Subject: RE: 3/2012/0765, single wind turbine at Old House Farm, Birks Brow

Regarding the application for a single wind turbine at Old House Farm, Birks Brow I am unable to complete my assessment of landscape and visual impacts due to a number of significant weaknesses and omissions with the applicant's Landscape and visual impact assessment. The principal of these are summarised below:

3 Zone of Theoretical Visibility Map

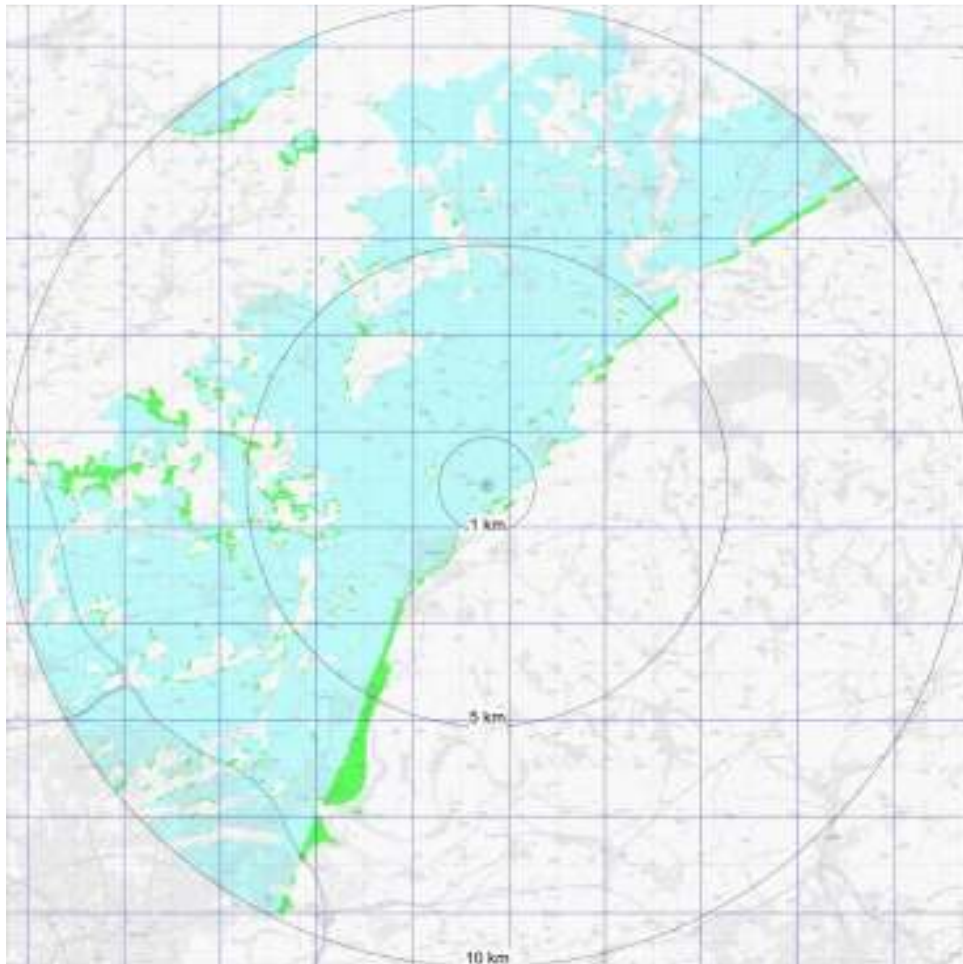
- the OS background mapping on the ZTV map is too blurred to be readable.
- the assessment of the landscape sensitivity of the Moorland Fringe landscape character type that the site lies within - "*medium to low sensitivity*" - is unsupported. According to the *Landscape Sensitivity to Wind Energy*

- no cumulative ZTV mapping has been provided.
- the methodology for ZTV production has not been provided and the photomontage production methodology is inadequate.
- the assessment of visual impacts lacks detail and is inconclusive. Receptors are identified but the consideration of the likely change in their view or the significance of change is inadequate.
- there is no assessment of the proposals against the key tests of landscape planning policy

Due to the issues outlined above I do not think it would be appropriate to determine the application. As an absolute minimum, accurate usable photomontages should be provided together with clear ZTV mapping (for the turbine on its own and in combination with other wind energy development) and a detailed explanation of the methodology used to produce these visual aids.
